PLANNING CONSULTATION RESPONSE

Application No	2025/0797
Proposal	Demolition and re-build of existing house with associated work to boundary walls (custom/self build)
Address	Berry Well, Kirkwood Bridge Lane, Spring Vale, Sheffield, S36 6AX
Date of Consultation Reply	24/11/2025
Consultee	Katie Lawrence, Planning Ecologist

DRAWING TITLE
Existing Site Plan

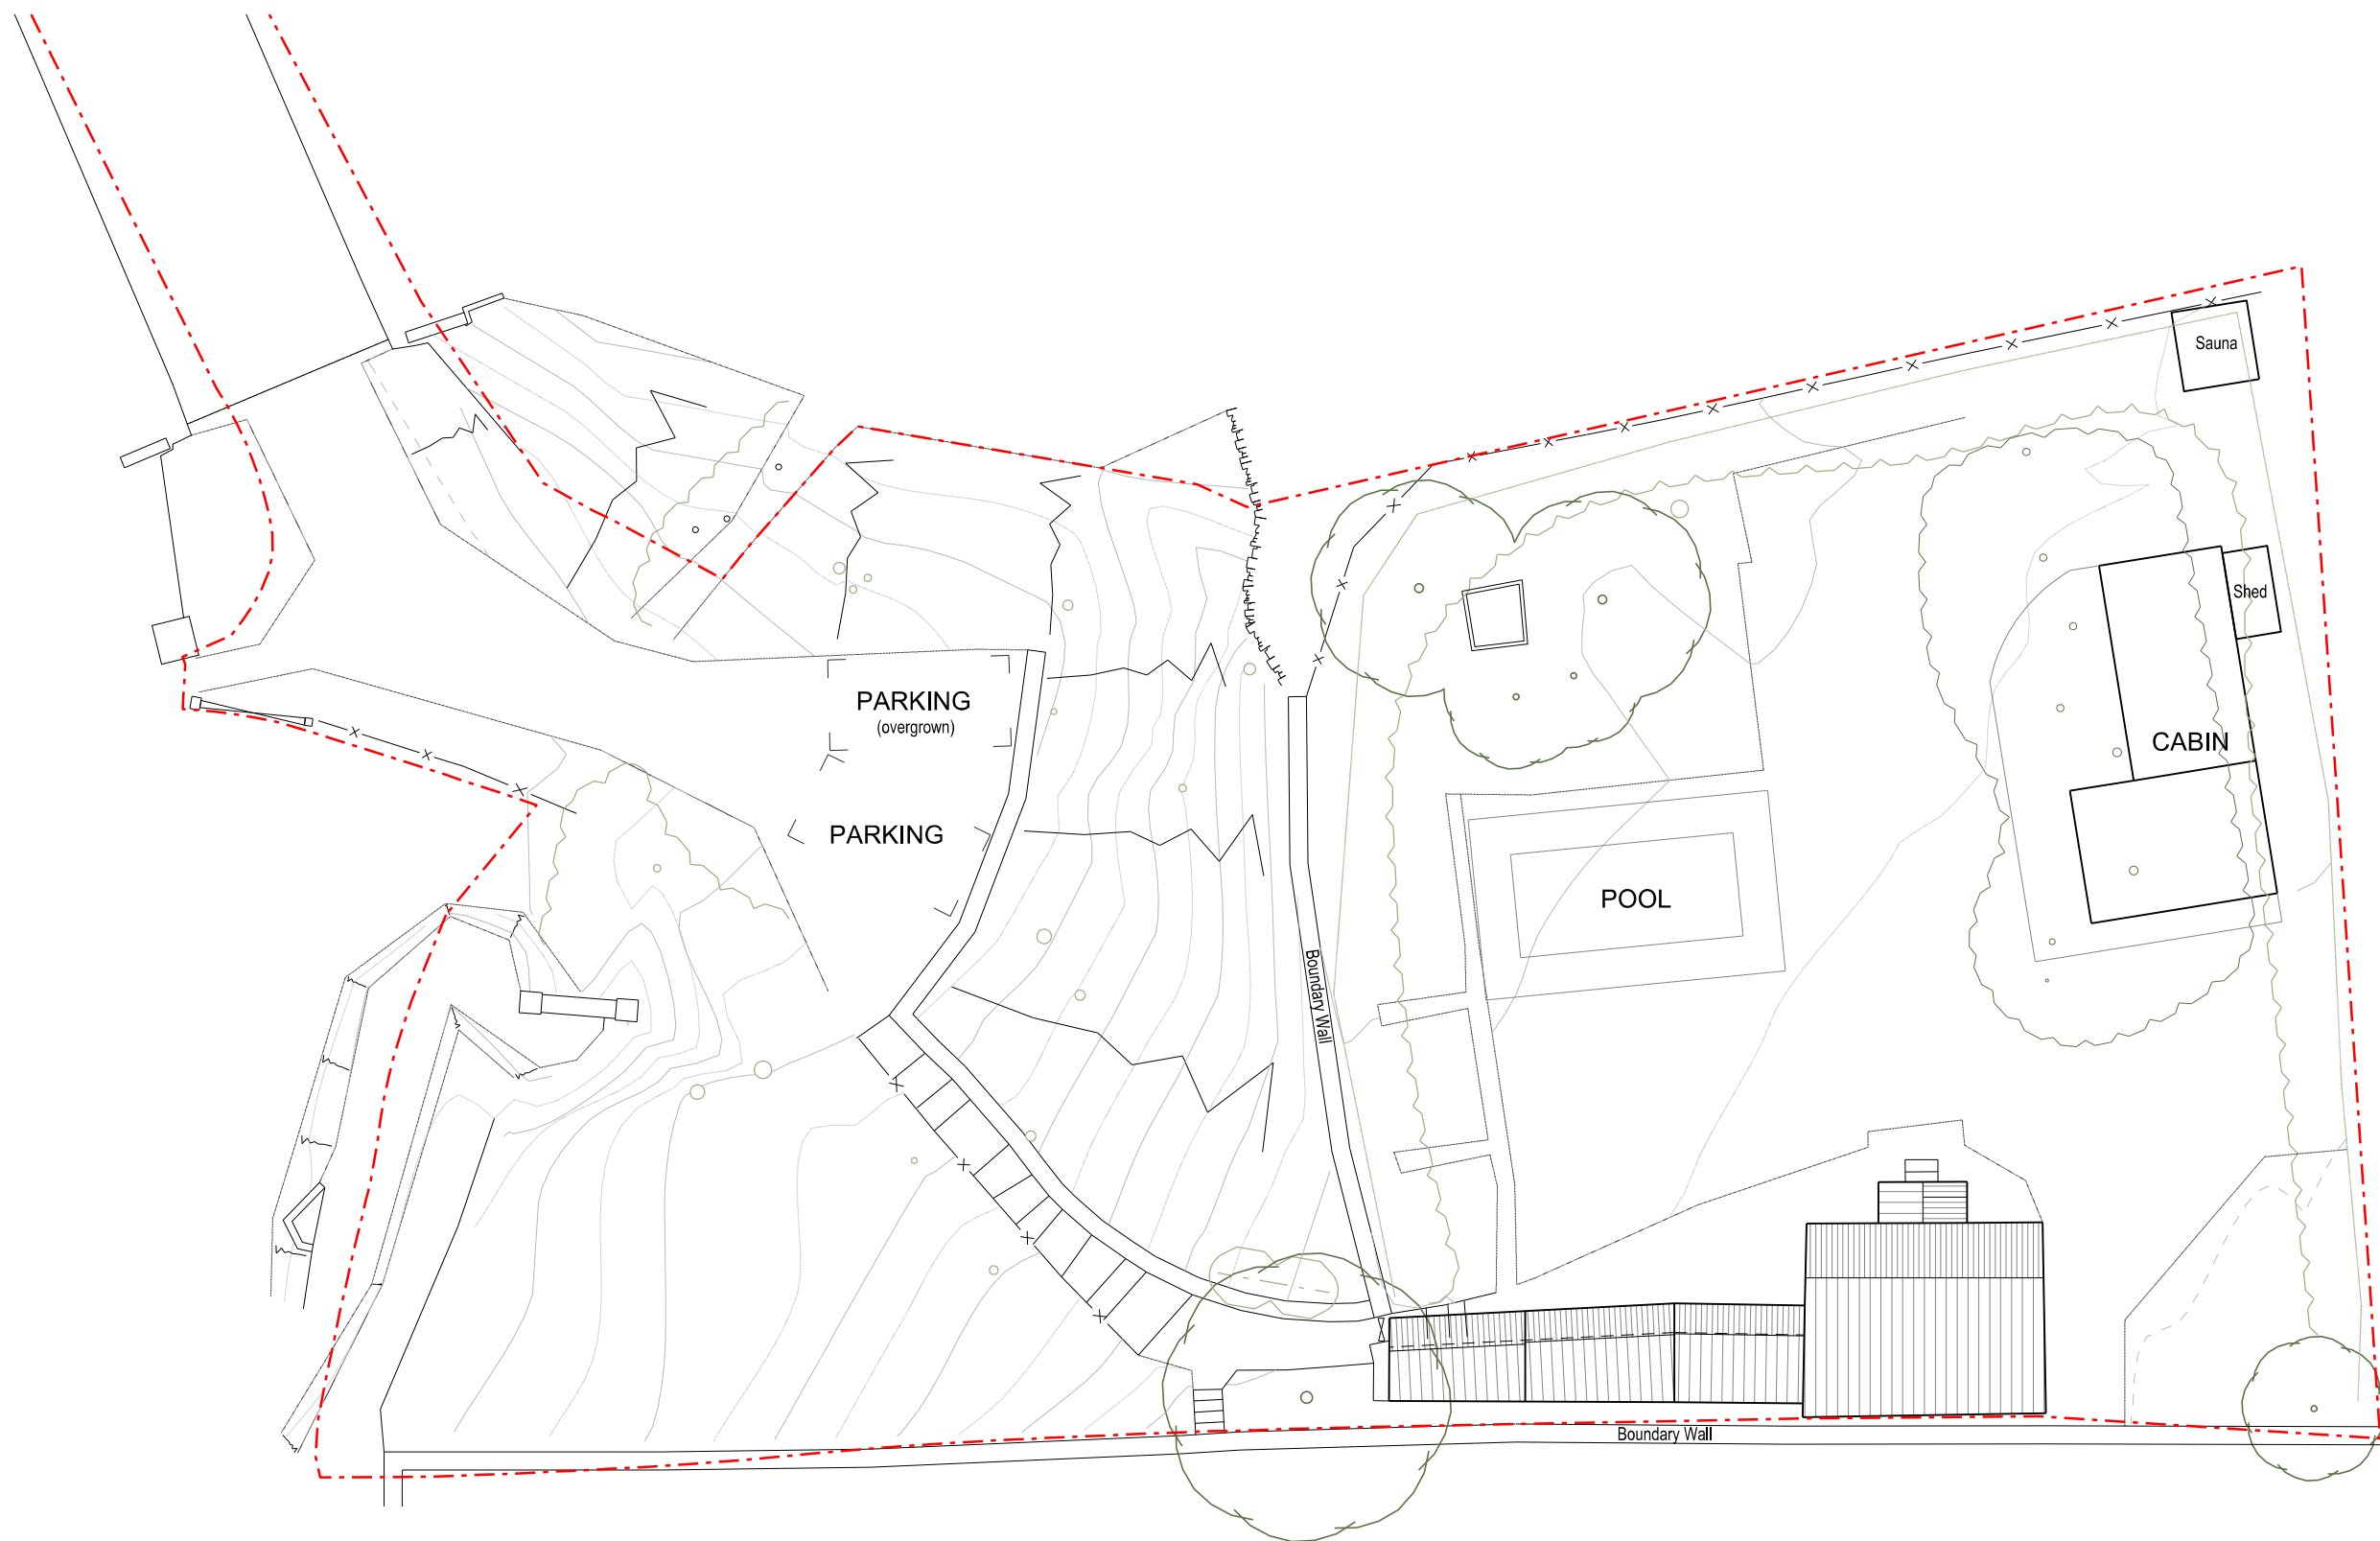
- The bat survey report details that the site comprises a swimming pond and a wildlife pond. There is no detail on these features in terms of their suitability for amphibians and the potential impact of the proposal upon such species. The proposed building footprint appears to be slightly larger than the current building, so there is a possible loss of areas of garden (lawn, shrubs, etc.) and therefore a potential impact to amphibian terrestrial habitat. The report should include further information regarding these ponds and the potential impact of the proposals upon amphibian species.
